## Fire Marshal Division

**RE: Hwy 55 Restaurant**  
**1600 N. Main St.**  
**Lillington, NC 27546**

**Application Number FMFW2004-0002**

Date: 1. 24. 20
 Scale: AS NOTED
 Project Mgr: DG
 Drawn: DV
 Job: 19-142
 Sheet
AS2

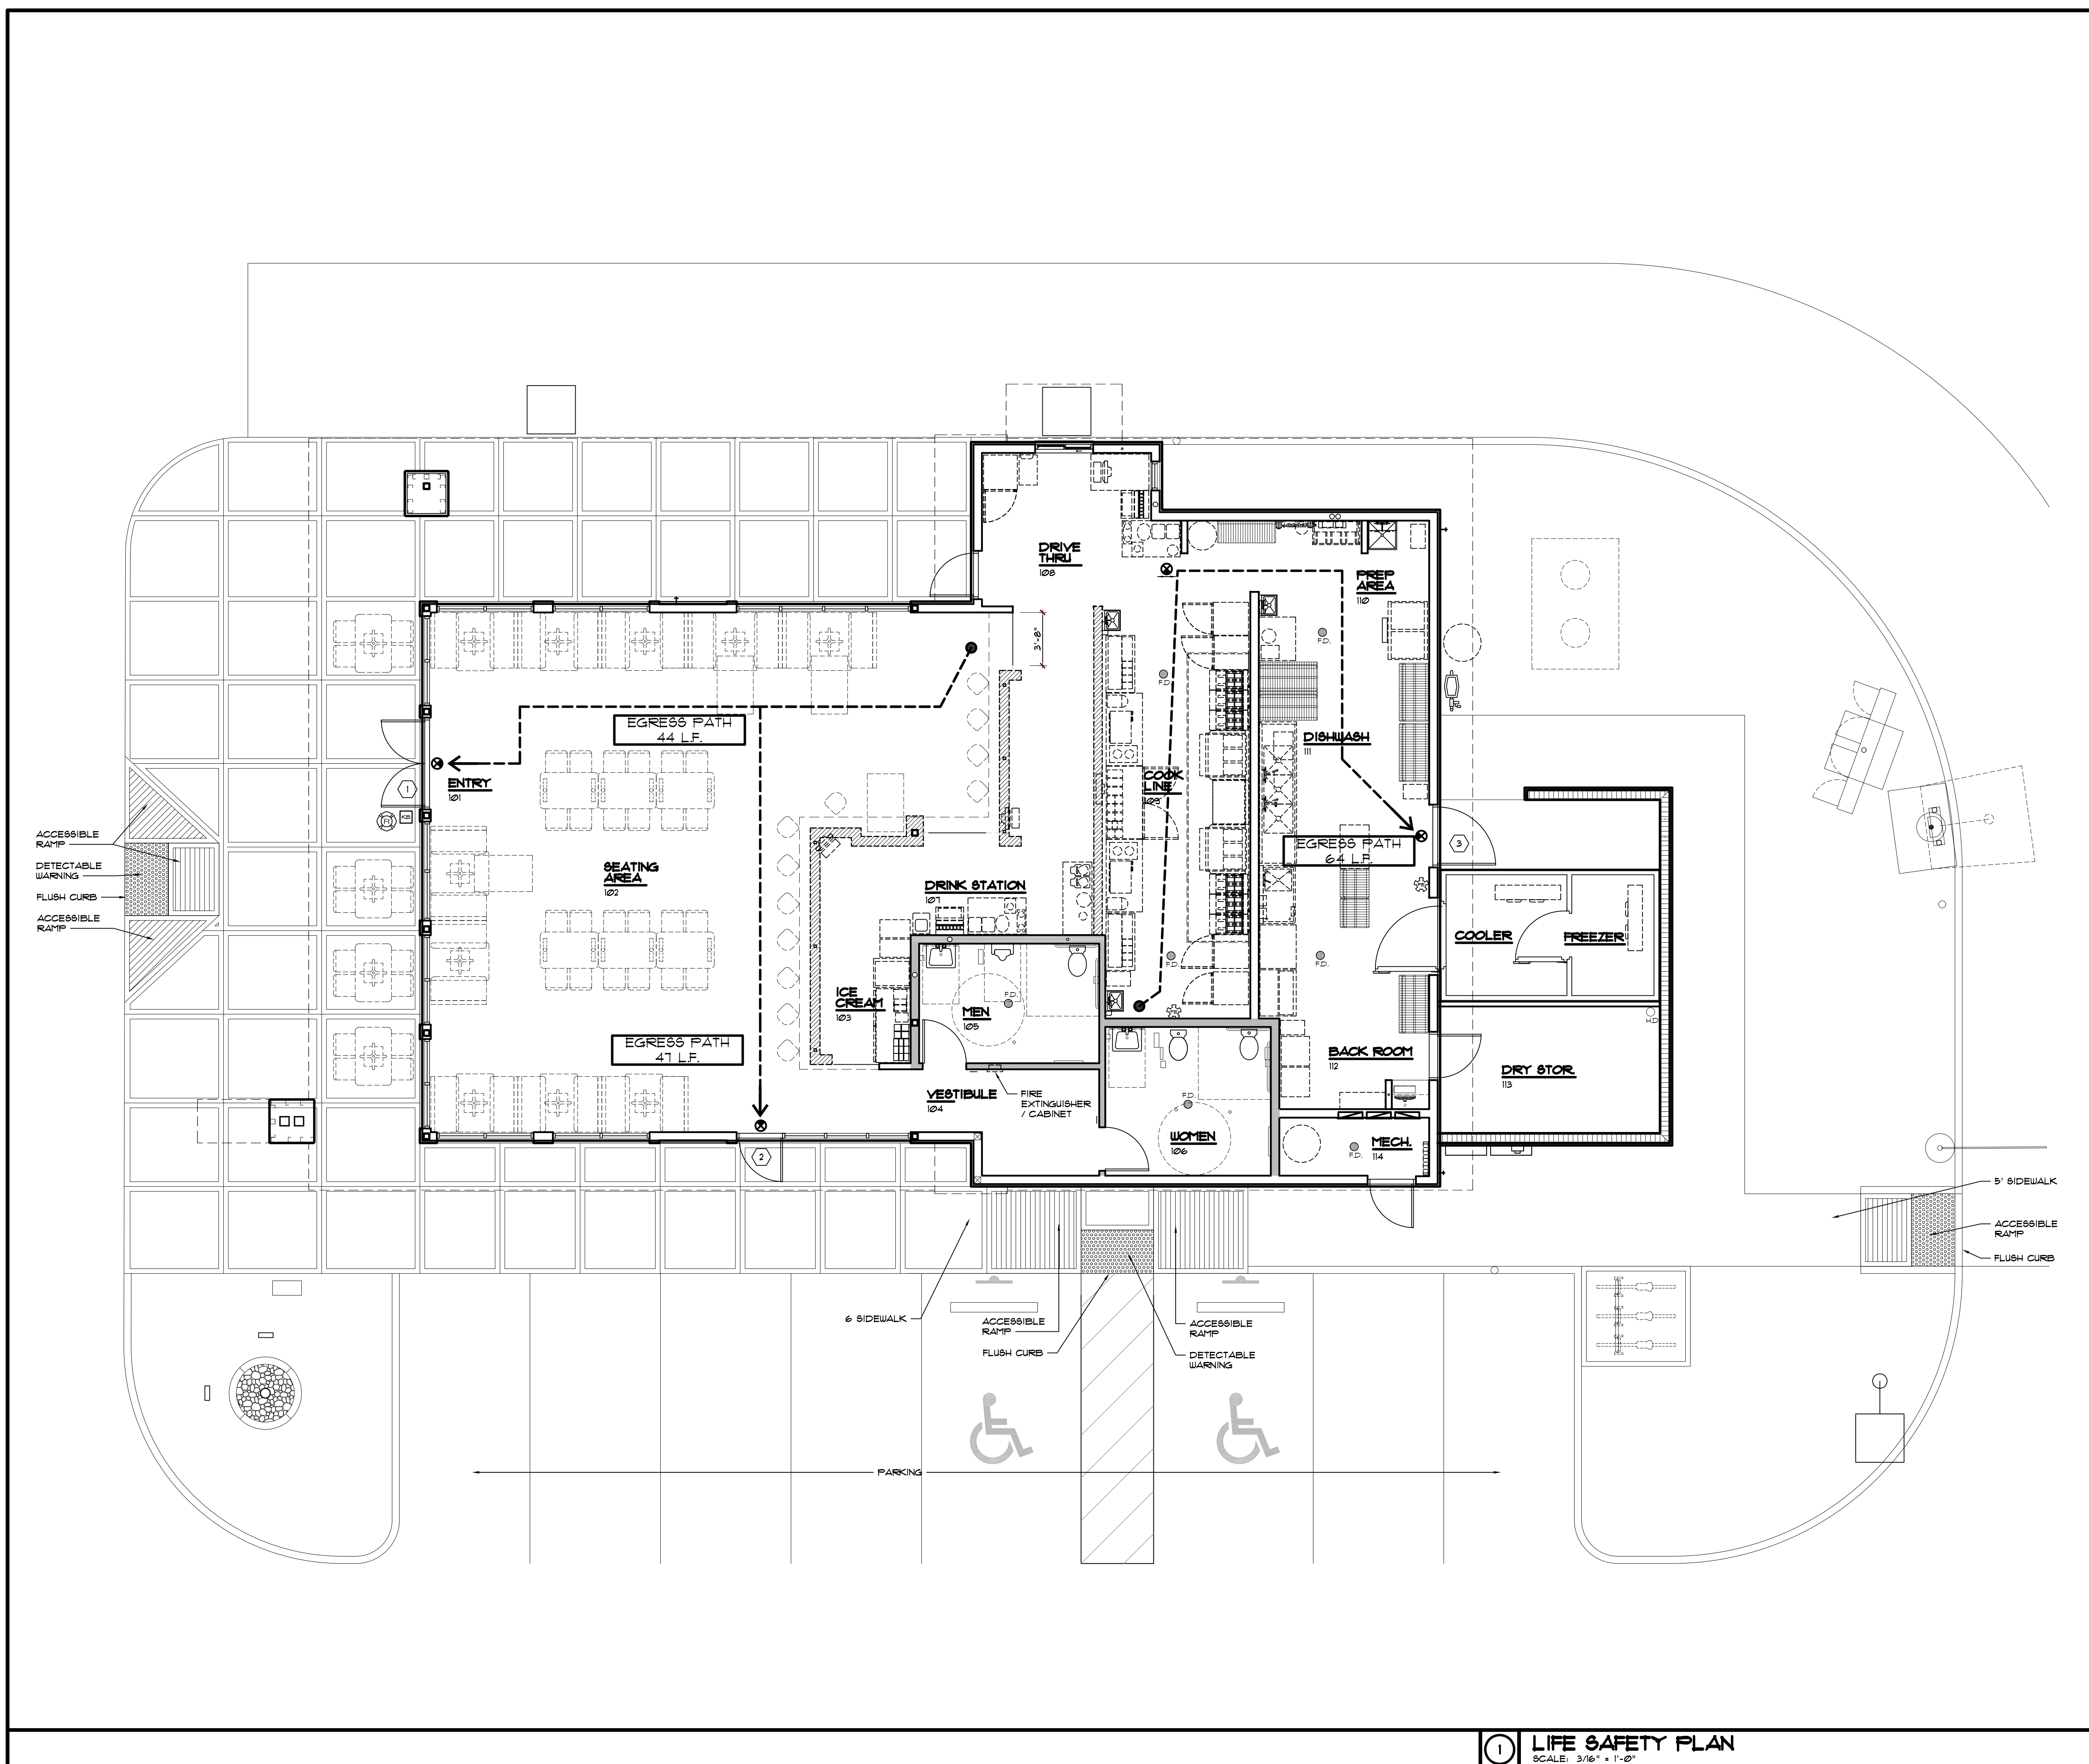
- 1. All Fire Suppression system and Fire Alarm requirements, indicated on master building plan review notes, must be met before Final C/O for the building can be issued.**
- 2. The diagonal distance between the second exit in the dining area is too close to the main exit. The remote exit should be  $\frac{1}{2}$  the diagonal distance of the building or greater from the main exit. Please review and submit changes.**
